From: Fiona Fitzgerald
Sent: 13 February 2019 10:15
To: Planning.Responses
Cc: Simon Davis
Subject: Y/49/18/PL

Environmental Health **object** to this application on noise grounds.

I refer to the Acoustic Report AS10285.180326.ADS by Clarke Saunders dated 31/5/18 and subsequent emails between the applicant, EH and ADC Planning.

Figure AS10285/TH1

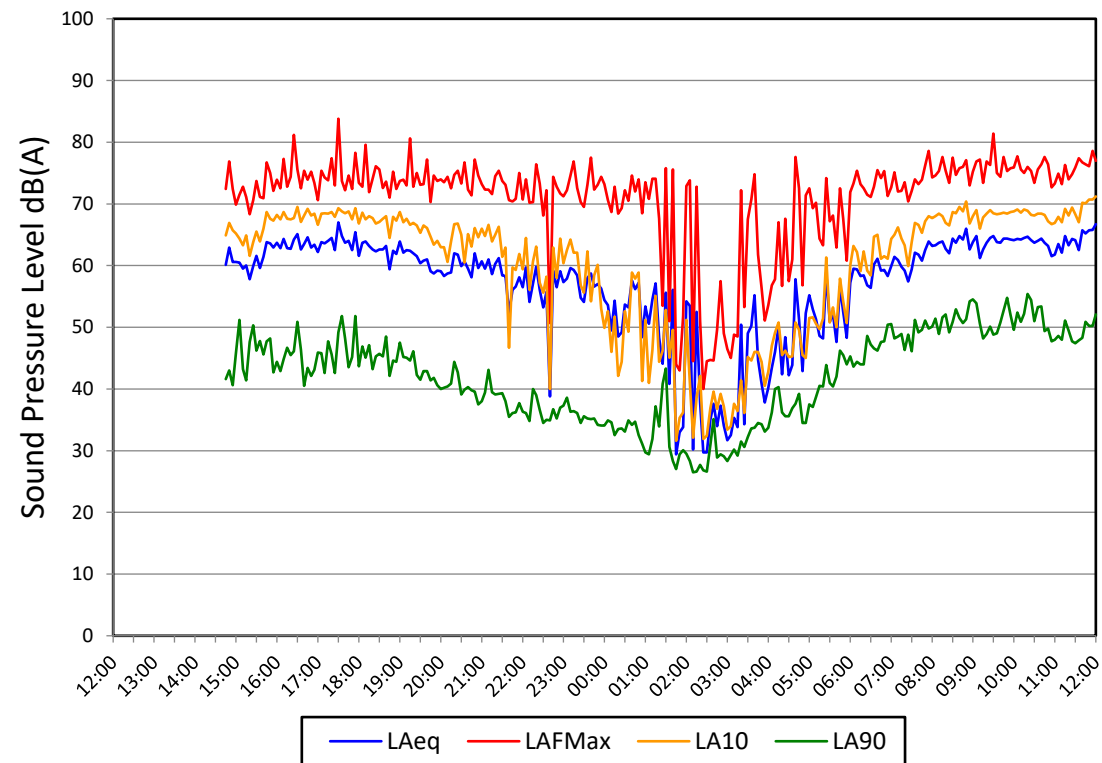
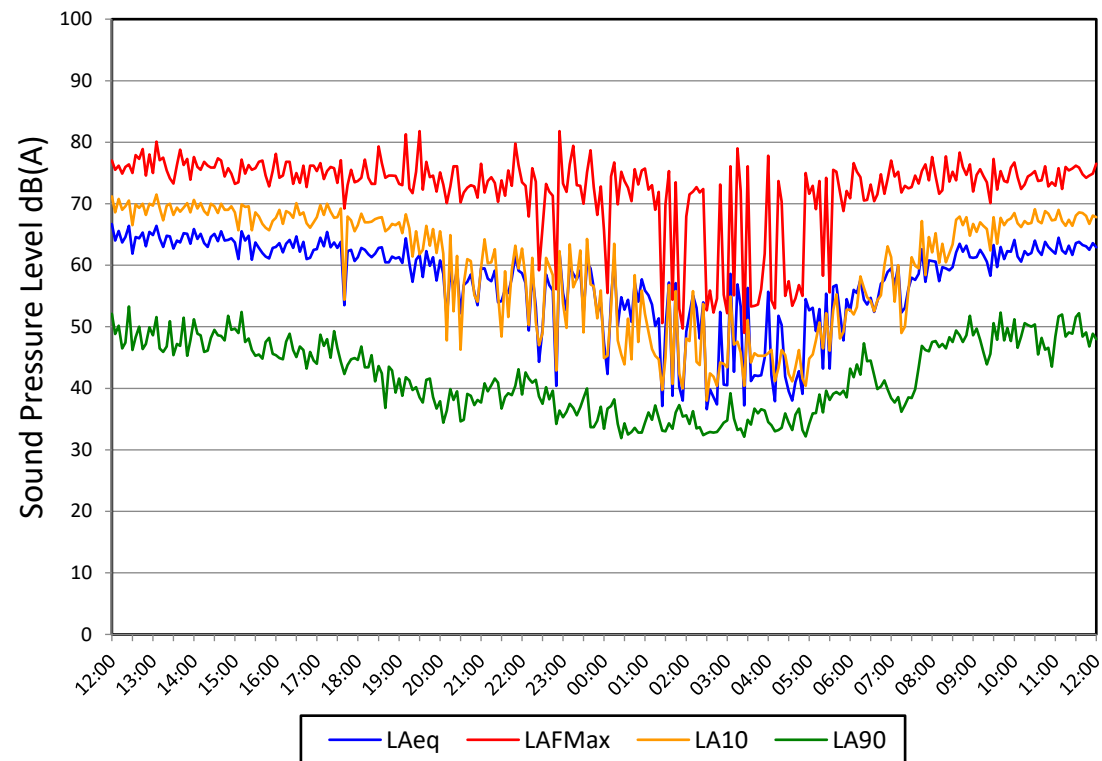
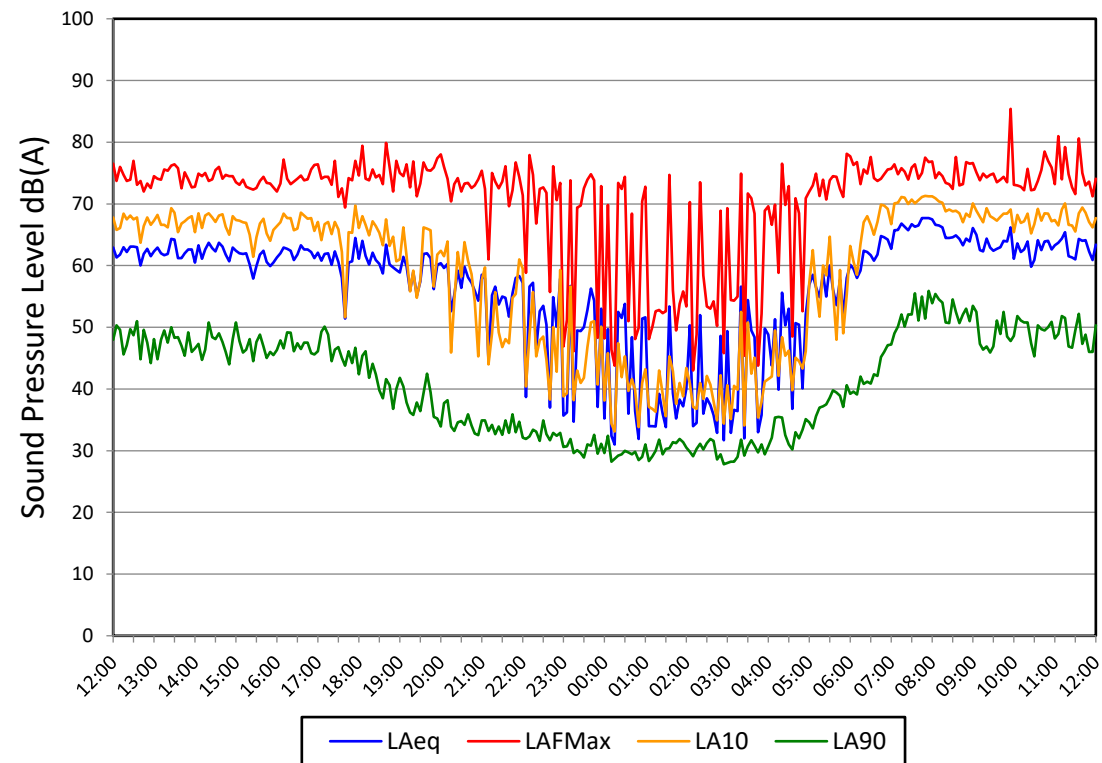
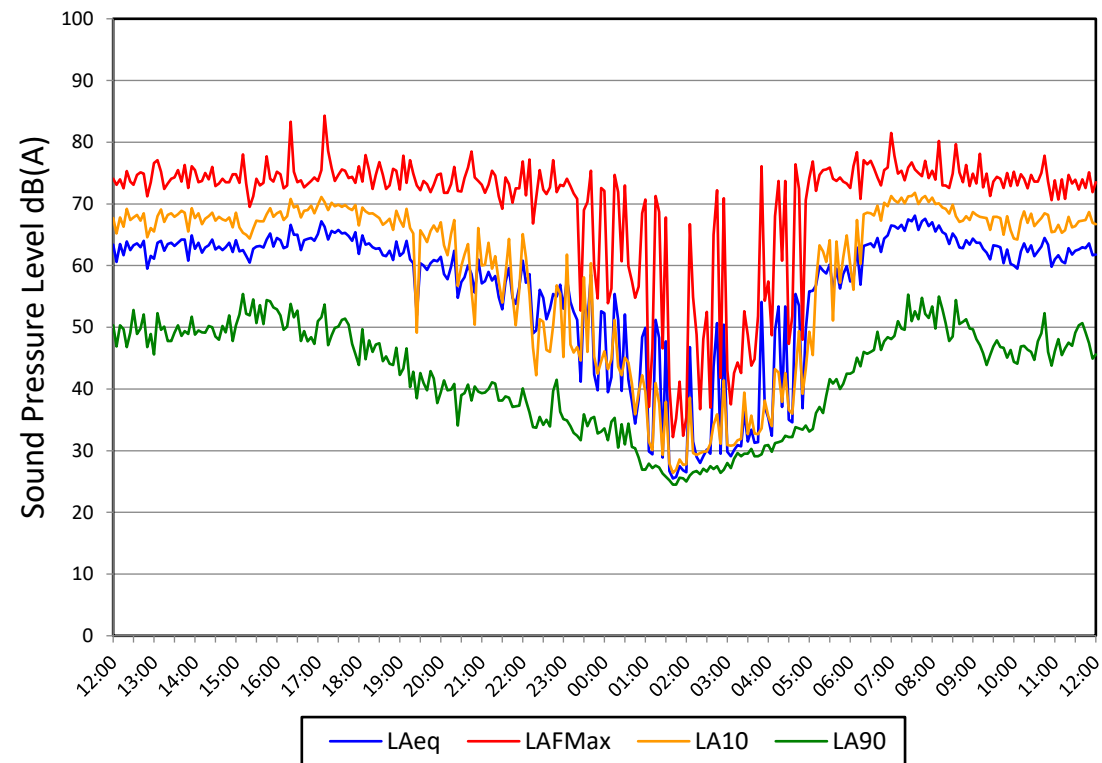
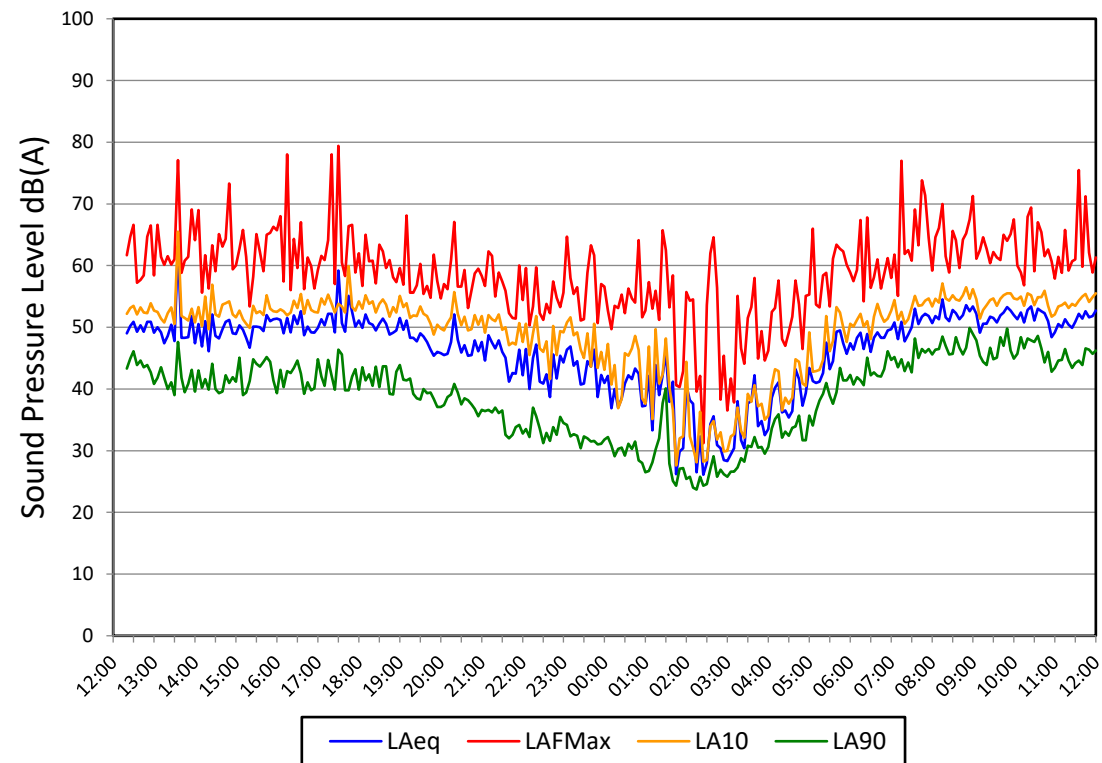
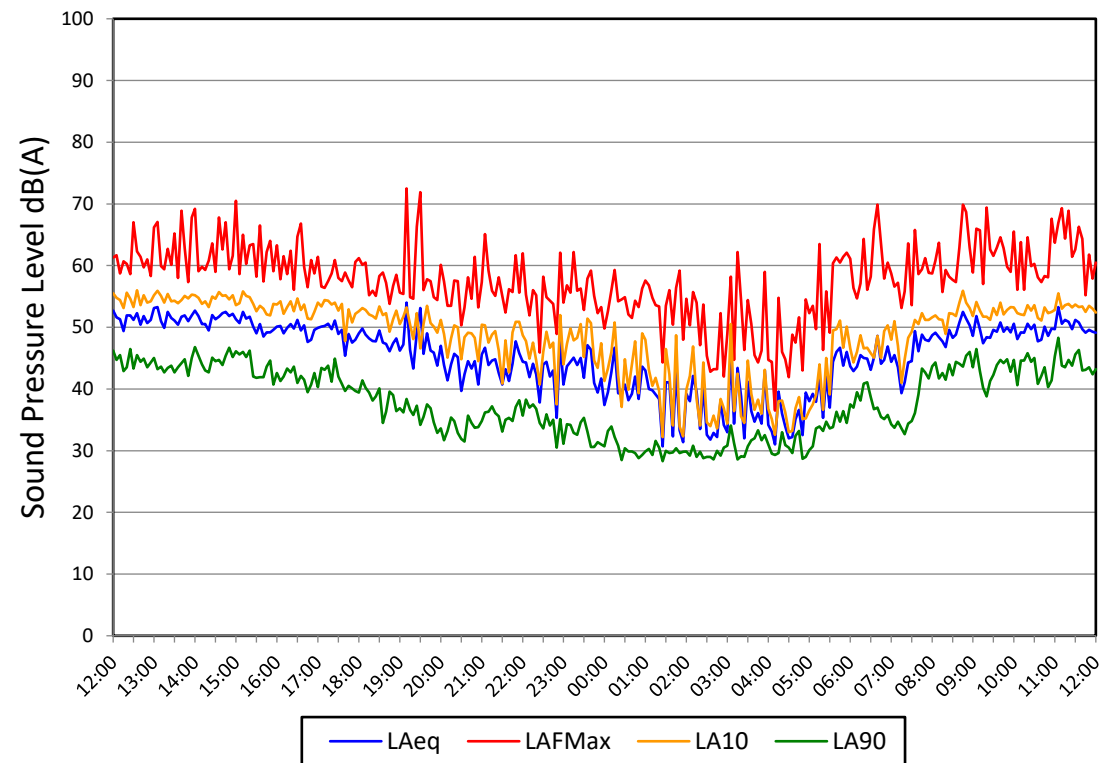
5. After reviewing the raw data it needs to be considered that this location has very high noise levels throughout the day, evening and into the early hours (2/3am) and no indication of the reasons for this has been provided. The proposals to mitigate this are to ensure that windows are sealed shut and alternative ventilation is installed. I believe this will not provide sustainable well built residential properties for future residents.

6. The noise levels in the raw data appear very high for this area, especially through the night, no explanation or justification for this was given in the report. My awareness of the noise environment for this site conflicts with the raw data given (for example LAeq of low 50's at 1 or 2am shown in the raw data).

scale	date	job no.	dwg no.	rev.
1:500 @ A2	MAY 17	1706	2.10	P2

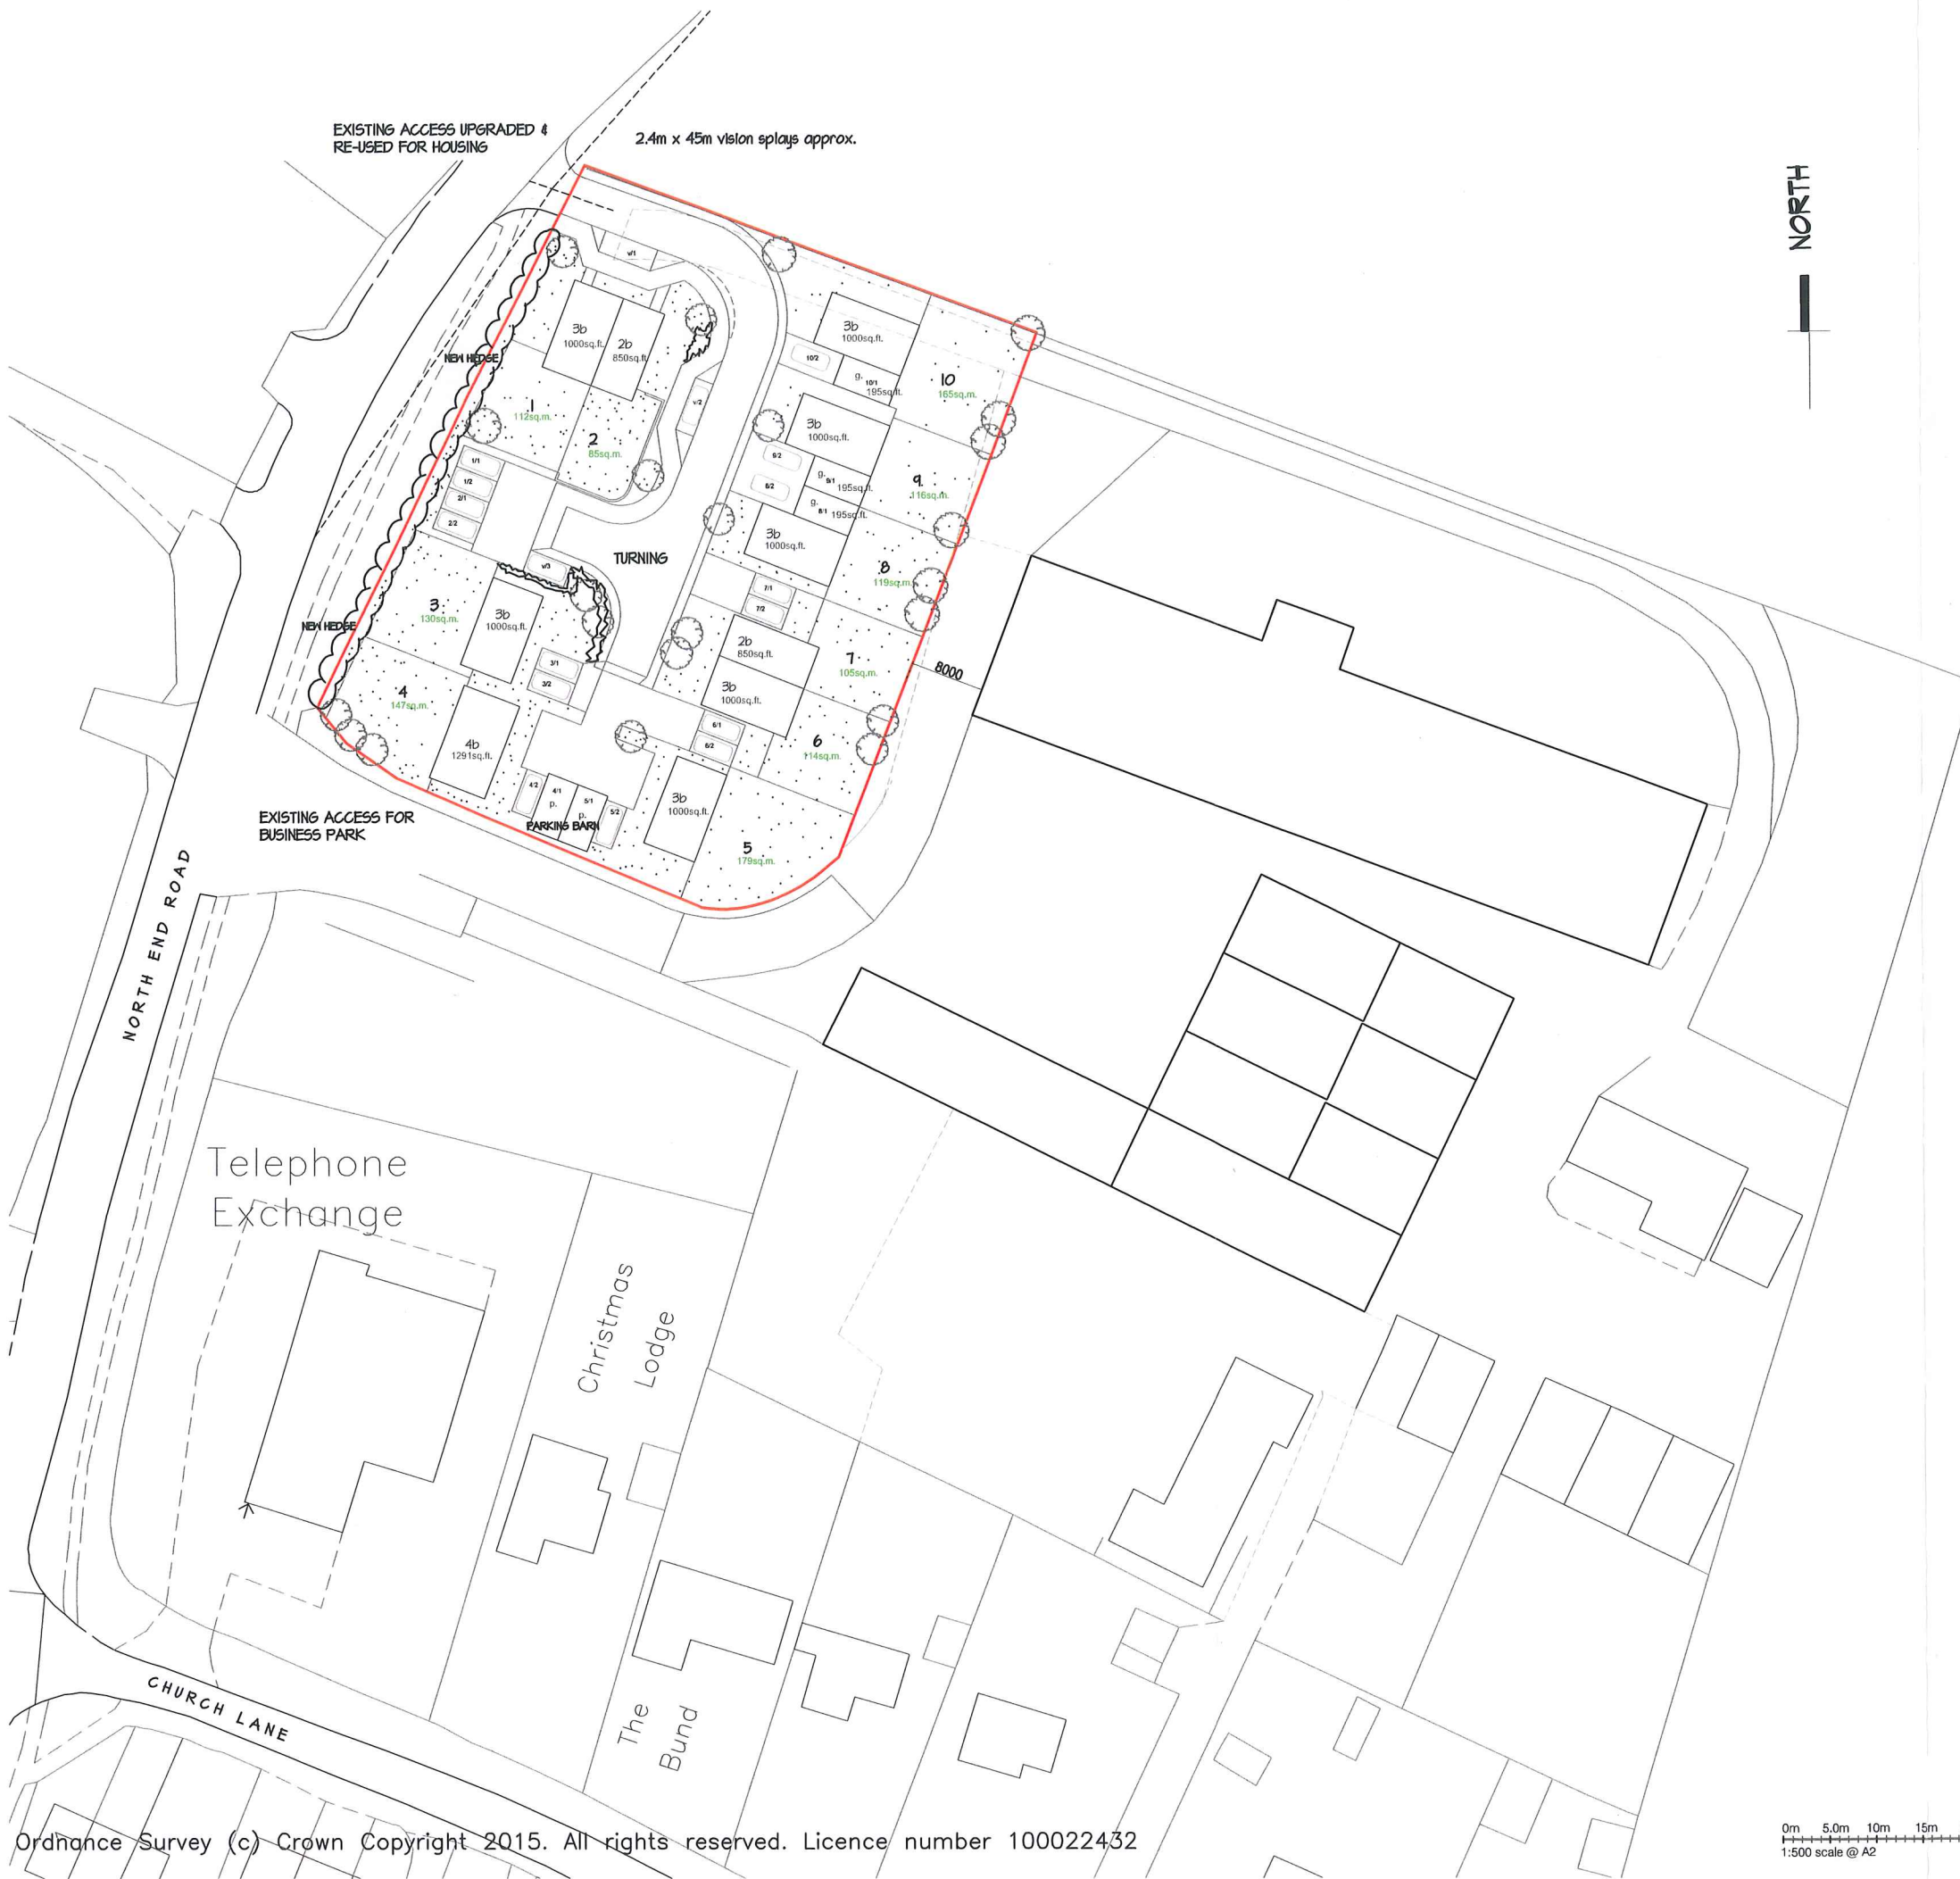
1. The site and plot layout don't appear to have been considered in order to mitigate noise impact sufficiently. Amenity land (i.e. garden) is placed closest to the known noise source (extractor fan).

4. From my visit with Daniel Saunders from Clarke Saunders on Friday 16th March 2018 I stood approximately where the garden of Plot 5 is proposed to be whilst the extraction unit from the industrial estate was on. It is my opinion that the noise from the extraction unit would constitute a Statutory Nuisance under the Environmental Protection Act 1990 and therefore the development, if approved, would curtail use of the industrial site in contradiction to the NPPF which seeks to avoid unreasonable burdens on existing businesses due to nearby changes to noise sensitive land use, specifically contrary to paragraphs 170e and 180 of the NPPF.
